Permit No: 05-1375	Issue Date: <b>PERMIT ISSUED</b> FEB 17 2006	CBL: 32001
Owner Address: 2 JUNIPER LN	Contractor Address: 84 Country Lane Portland	Phone: 2077728629
Permit Type: Multi Family	CITY OF PORTLAND

Location of Construction: 49 CARRIAGE LN (lot # 12)	Owner Name: Dwight Brackett & Co. INC
Business Name:	Contractor Name: Dwight Brackett
Lessee/Buyer's Name	Phone:
Past Use: Vacant Land	Proposed Use: Residential 34x75 5 unit w/ 2 bedroom per unit
Proposed Project Description: 34x75 5 unit w/ 2 bedroom per unit

10/25/2005-mjn: need Cert Forms, Statement of S/I, Geotech .....Questions about sprinkler (13D) . Applicant and Architect notified

FIRST FLOOR FRAMING PLAN SCALE : 1/4" = 1' - 0"

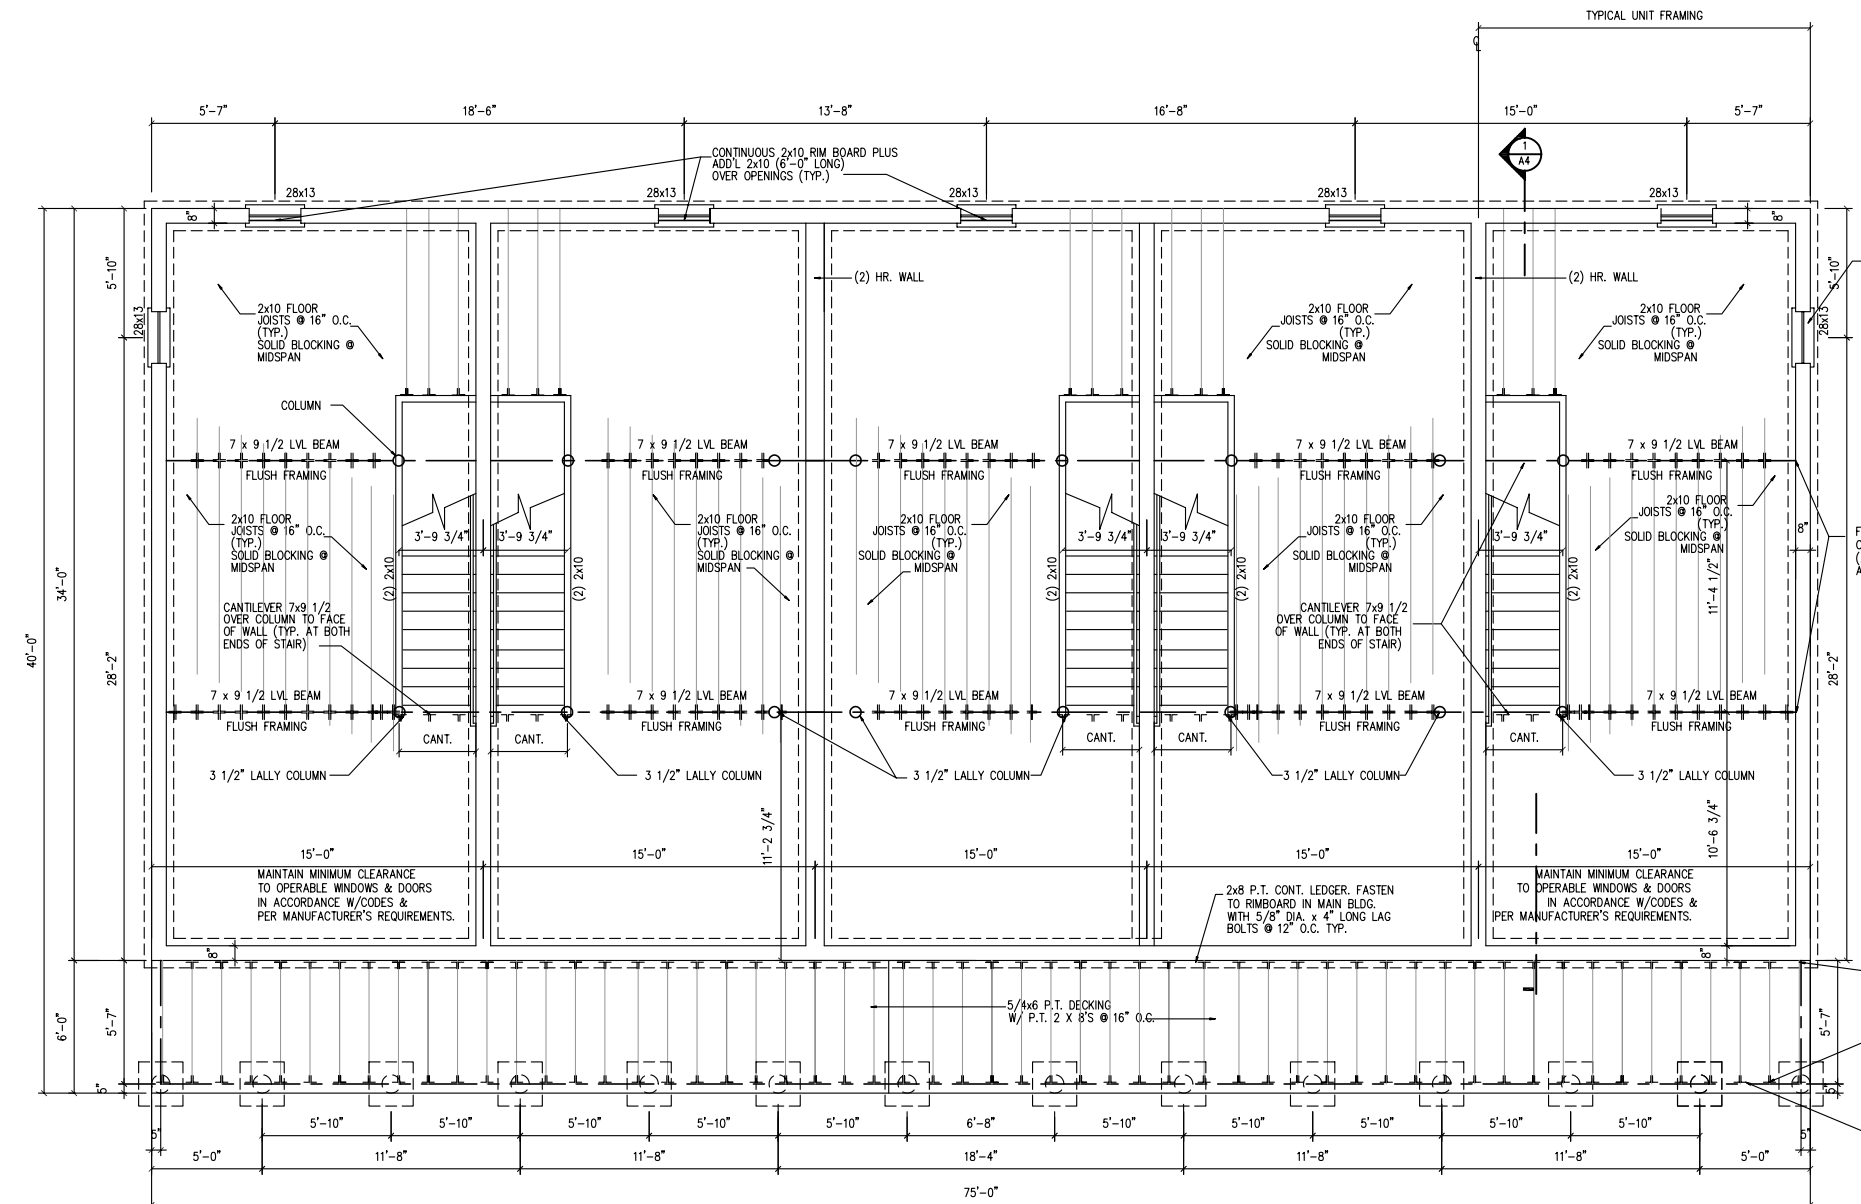
Cantalever issues

- 1) NEED STC'S
- 2) CANTILEVER NOT ALLOWED SEE TABLE R502.3.3
- 3) AMBIGUITY IN PLANS FOR FIRE SEPARATION IN ATTIC.
- 4) CANTILEVERED GIRDER.

2 PARTY WALL DETAIL (UL # U305 SIM.) 1 1/2" = 1'-0"

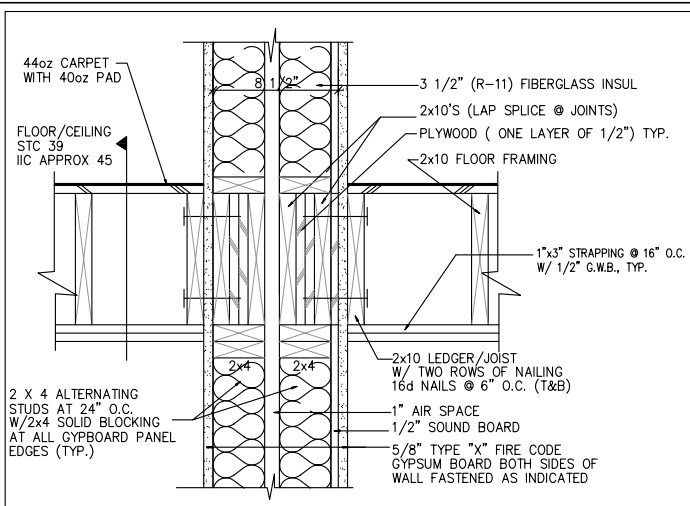
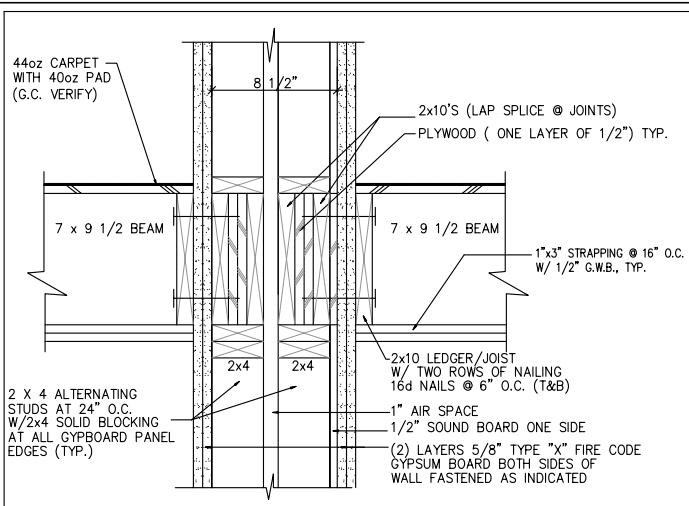
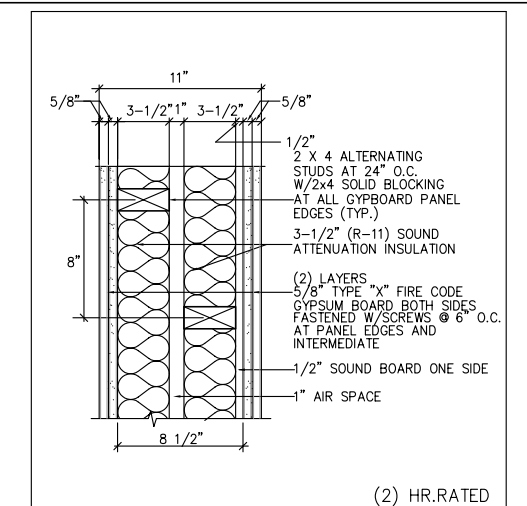
- 1) Statement of Special Inspections
- 2) Certifications
- 3) Founadtion perimeter drain plan that complies with code
- 4) RES or COM check compliance plan for Energy Efficiency Code Compliance
- 5) Sound transmission class for party walls
- 6) The Cantalever for the First/Second floor /ceiling assembly exceeds the limitations of Table R502.3.3 of the IRC.
- 7) What type of Heating system/Ventilation?
- 8) Will need a statement of design from the LVL manufacturer that the proposed Cantalever in the basement /first sloor assembly is consistant with the bearing capability of their product.
